From: Jo Edwards
Sent: 06 April 2022 17:41
To: Planning.Responses
Subject: App Ref: LU/61/22/PL- Linden Park Recreation Ground - Sport England Ref: PA/22/SE/AR/61108

The proposal is for the construction of a new fibre broadband exchange at the southern end of the recreation ground and the installation of a new 4m wide access road and turning head on the east side of the recreation ground.

Drawing Title
PROPOSED SITE PLAN

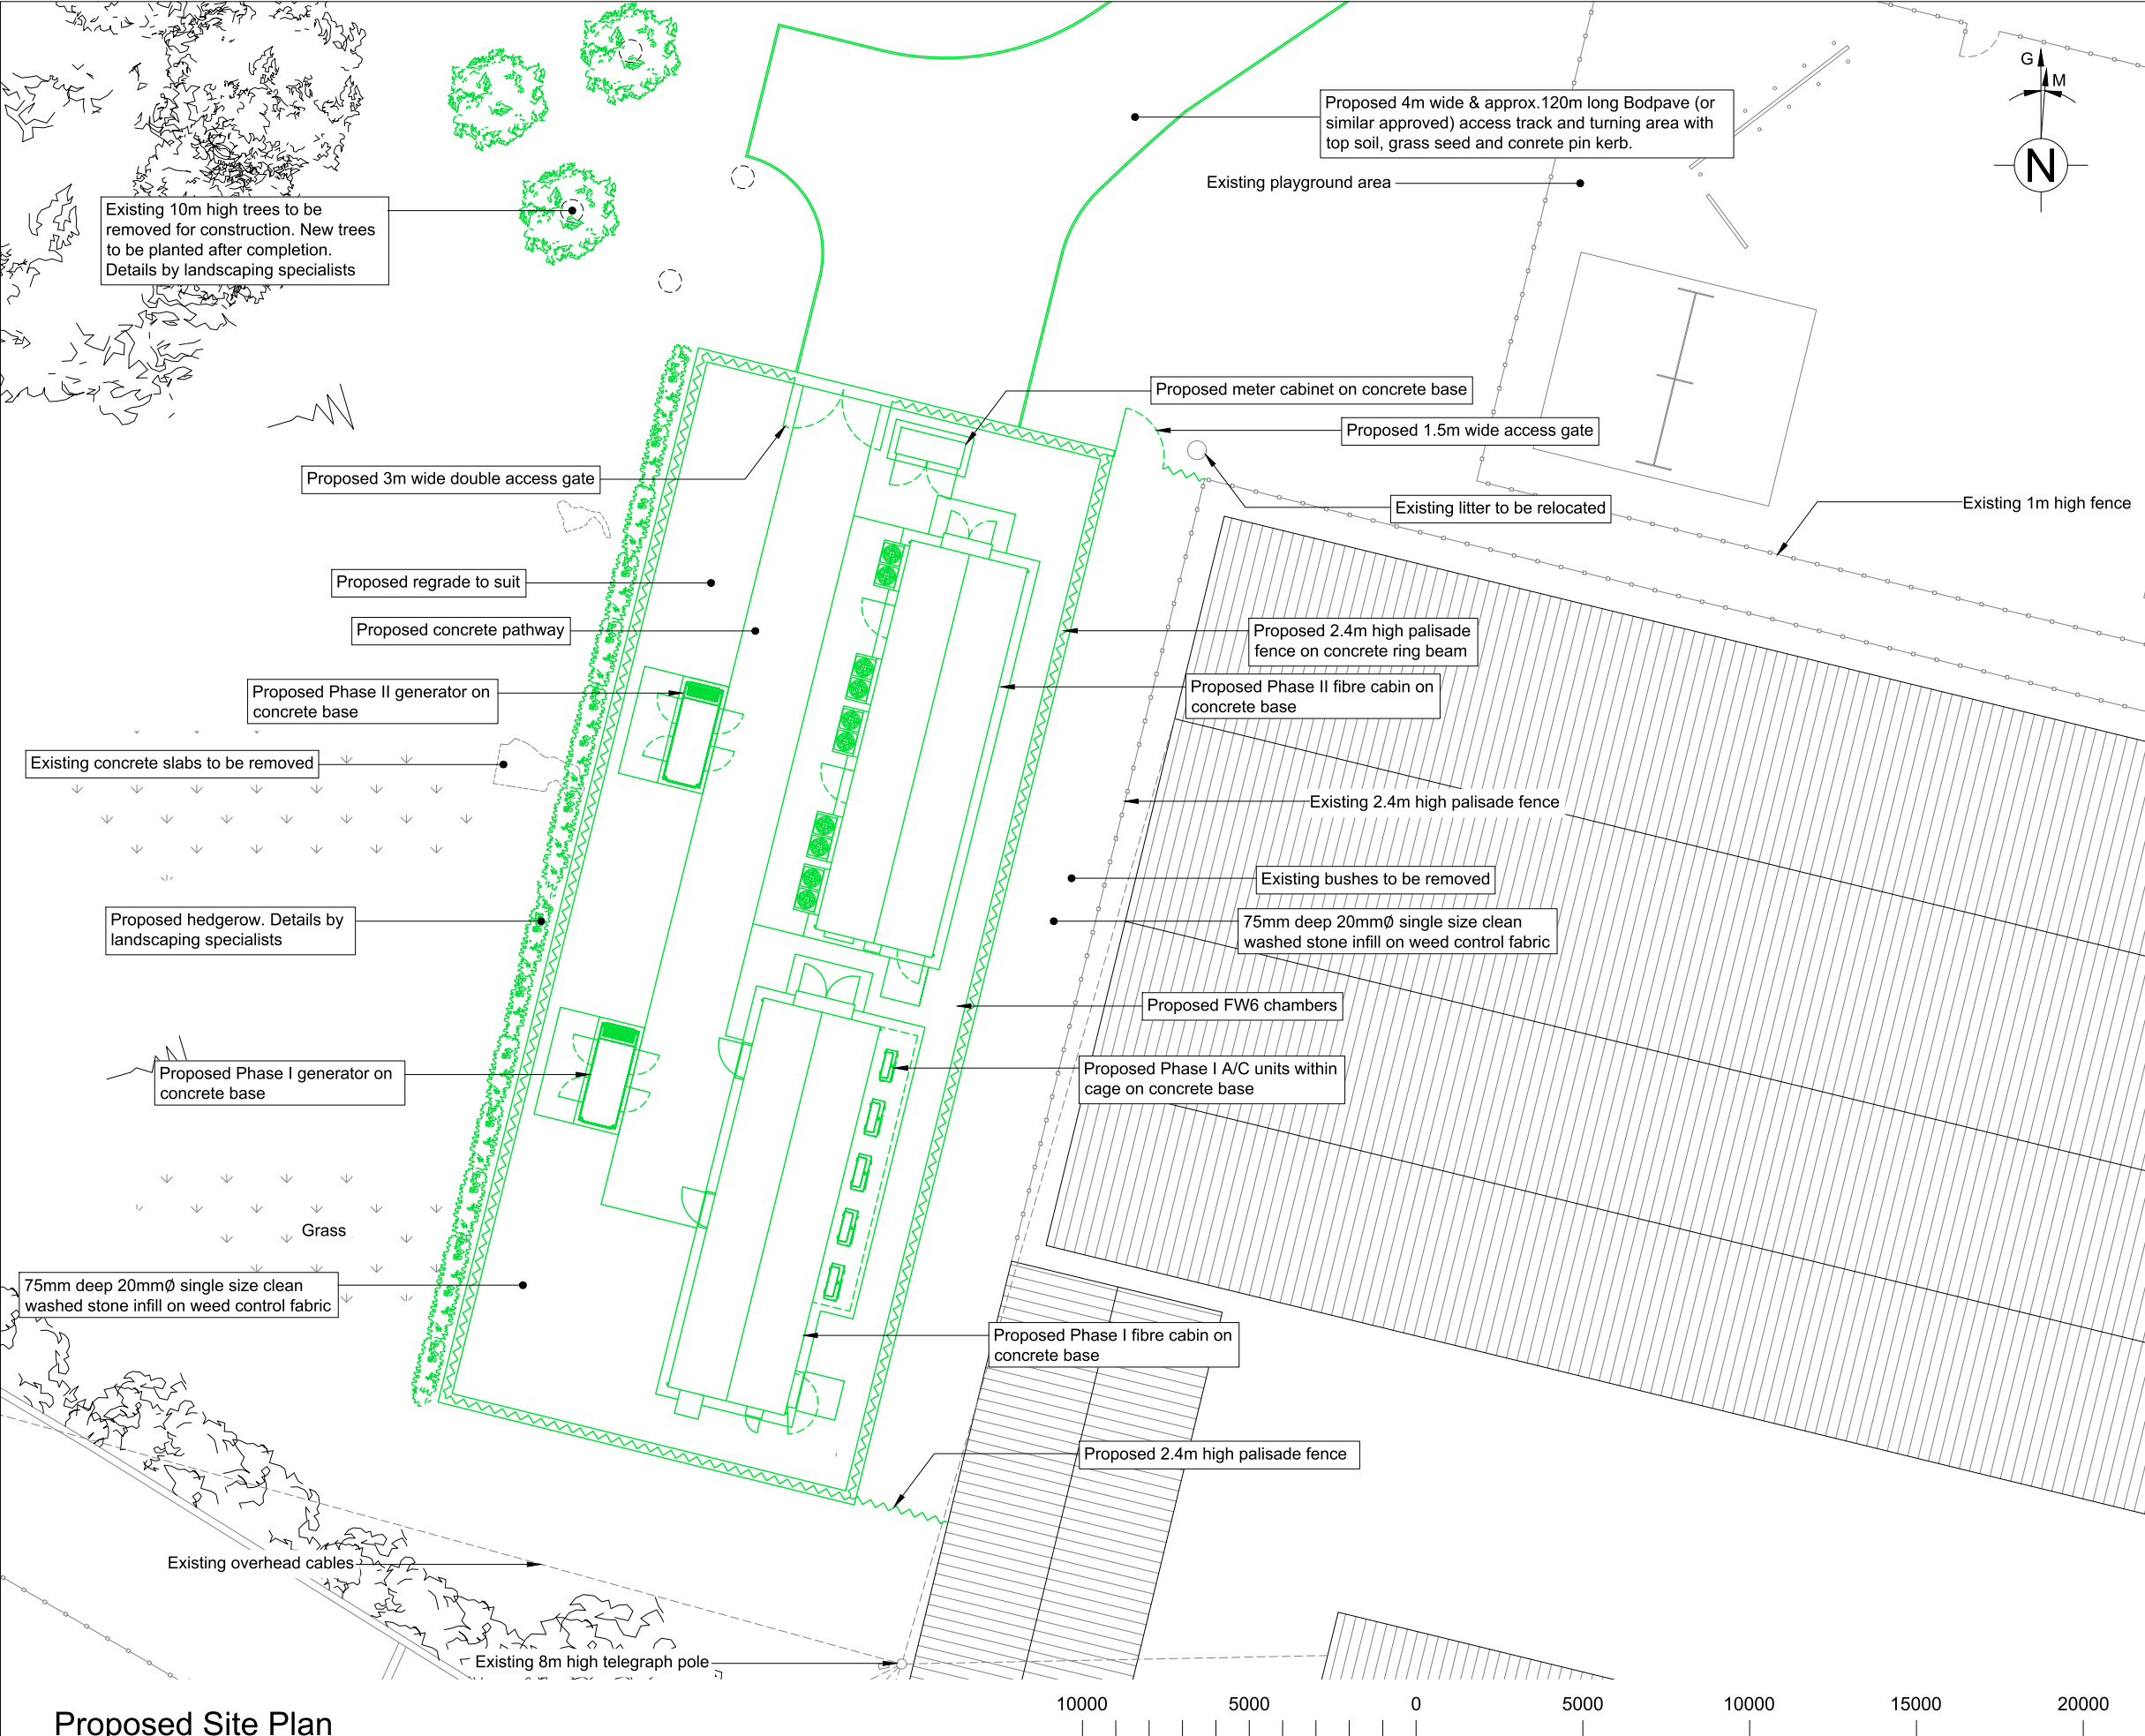
The proposed site plan demonstrates that the access road would be sited within less than 6m of the existing football pitch goal post and that the road and turning head would also encroach onto the area of land associated with that goal that would be expected to form part of the pitch and its safety run off area beyond.

That being the case, Sport England **objects** to this application.
